Date 18 October 2023  
Our Ref 23/01224/FLH

**Town and Country Planning Act 1990 (As Amended)**  
**24 The Parade, Epsom, Surrey**  
**Re-alignment of front garden wall, new gates across driveway, single storey rear extension and replacement windows to property**

Proposed
floor plan

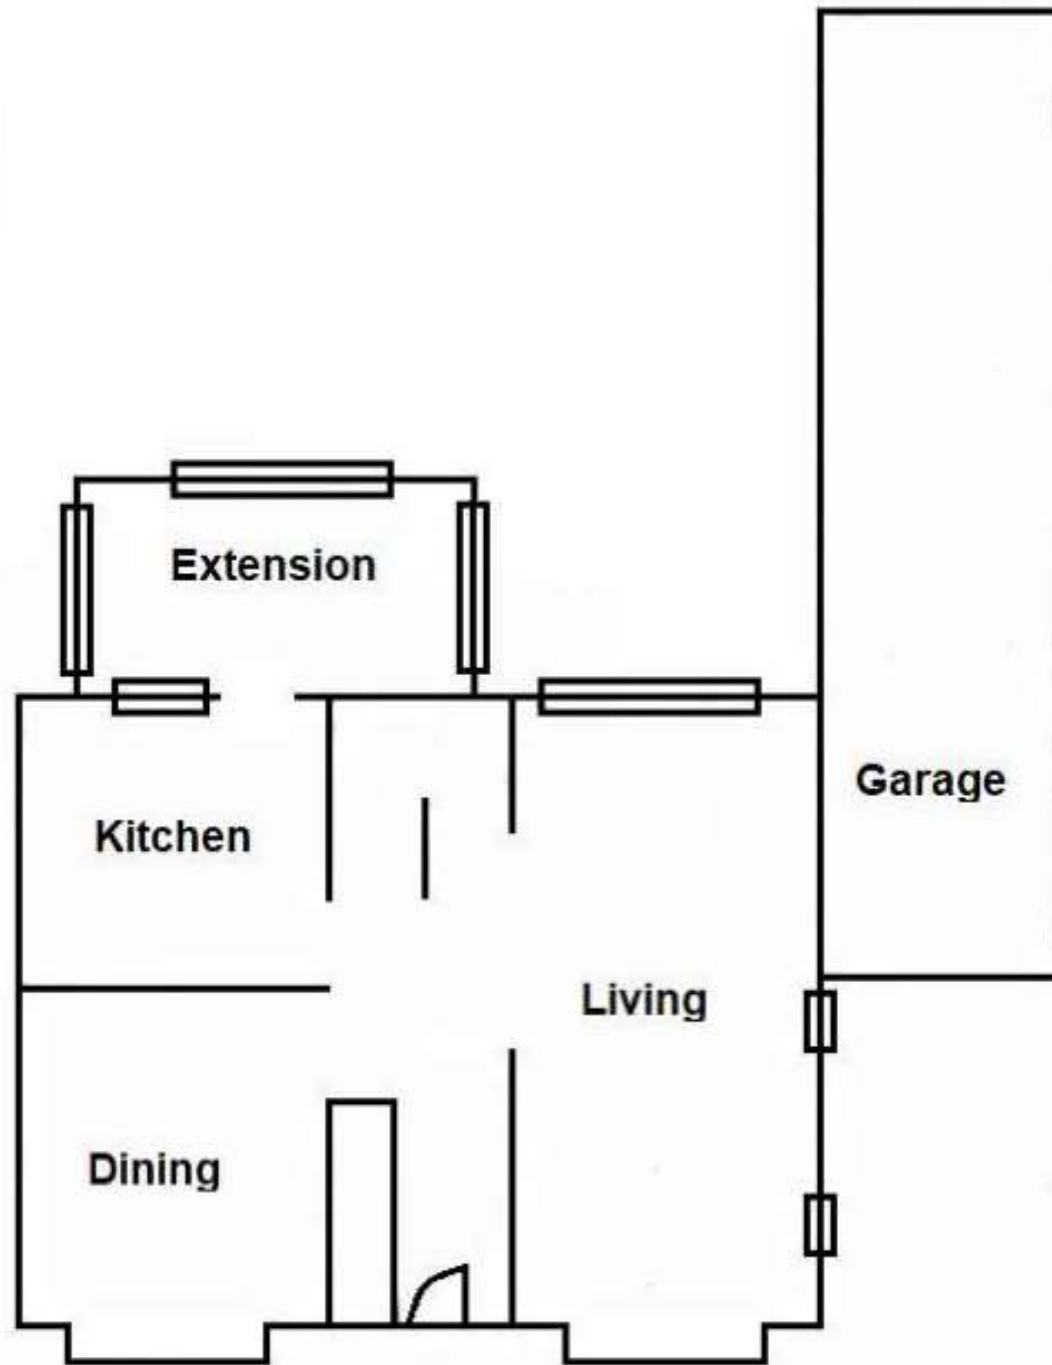
3 The drawings that have been submitted do not allow us or members of the public to adequately determine the siting and appearance of the proposed development. Detailed drawings must be provided, which should clearly show the relationship of the development with the application property and the neighbouring properties. Specifically, please submit existing and proposed floor plans (including roof plan) and all elevations to detail all aspects of the proposed development at scale 1:50 or 1:100
